Griffith BESS

Transport Impact Assessment
SSD-85372970

onemilegrid previously prepared a Transport Impact Assessment of the proposed Battery Energy Storage System (BESS) development at 15 Bob Irvin Road, Yoogali. This report has been prepared to provide additional information as requested in the Transport for New South Wales (TfNSW) Response to Environmental Impact Statement dated 24 December 2025.

Our responses and references to the items relevant to traffic engineering and transport planning of the TfNSW RFI dated 24 December 2025 are provided below.

INTERSECTION OF:
KIDMAN WAY AND HANWOOD AVENUE
HANWOOD

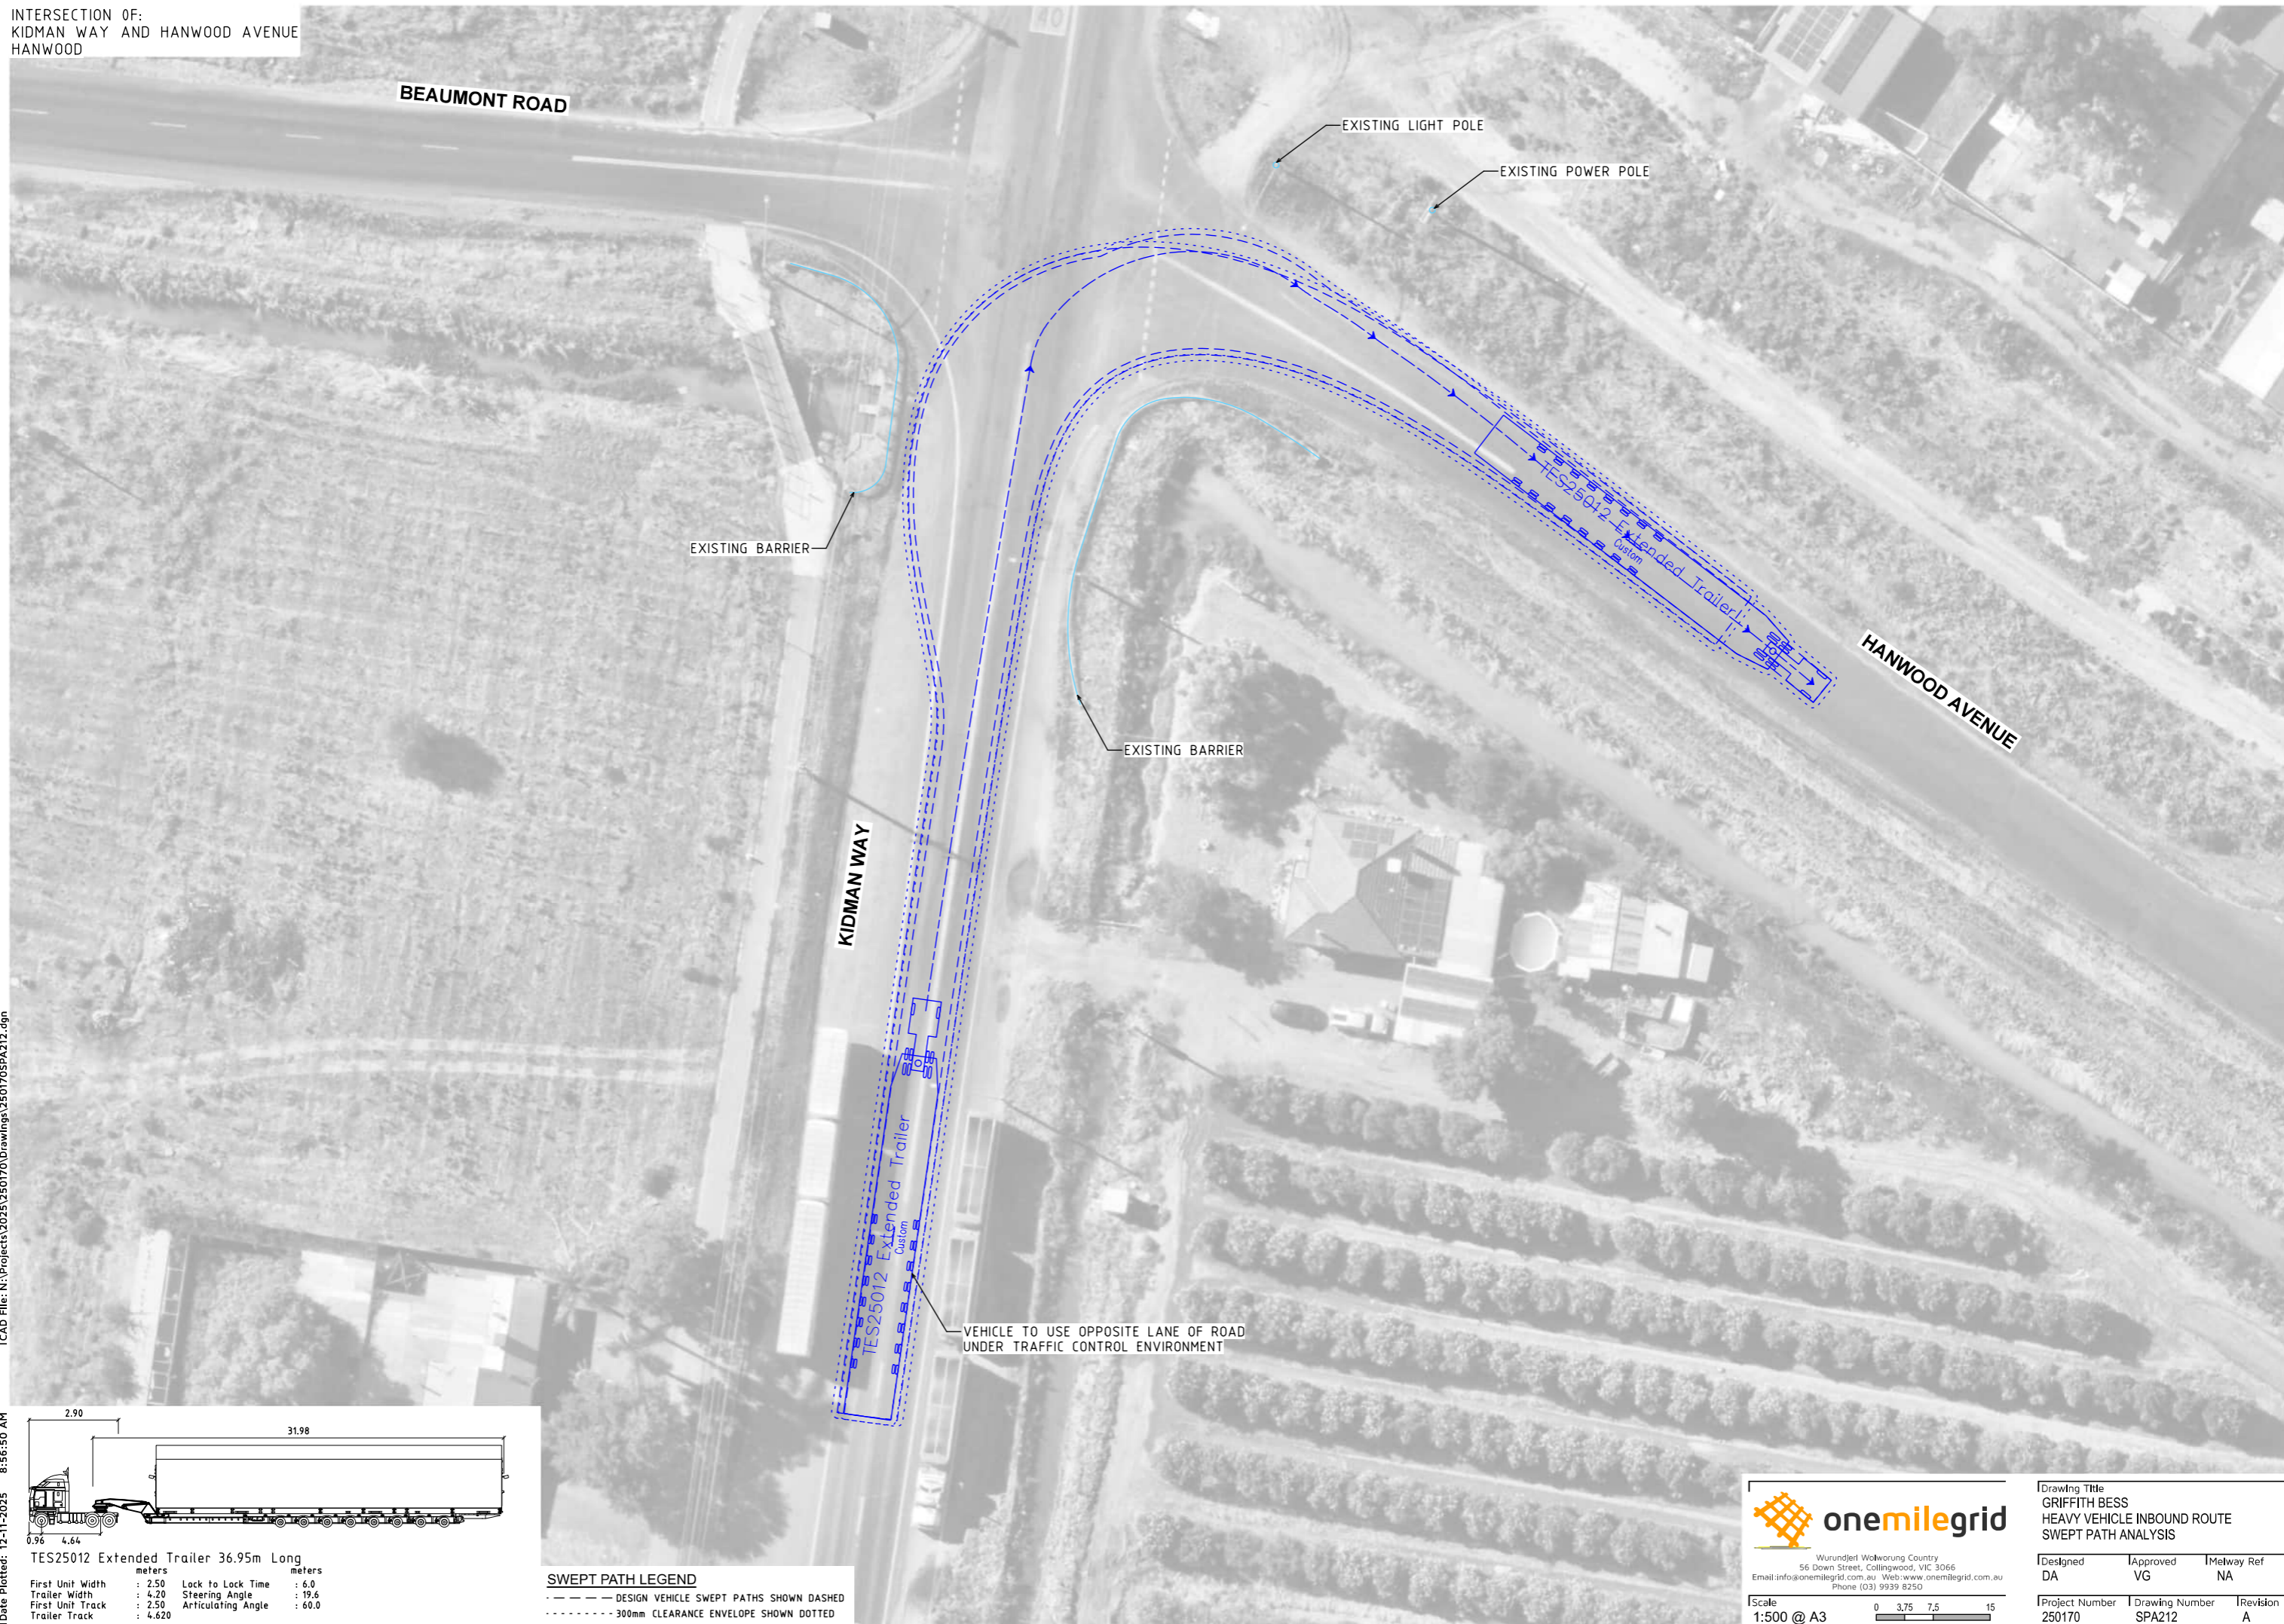
a) Swept paths are required, demonstrating the largest vehicle to use the intersection. Must be prepared in accordance with Austroads Design Vehicles and Turning Path	Please refer to Appendix B for swept path diagrams for Irrigation Way / Bob Irvin Way and Kidman Way / Hanwood Avenue intersections.
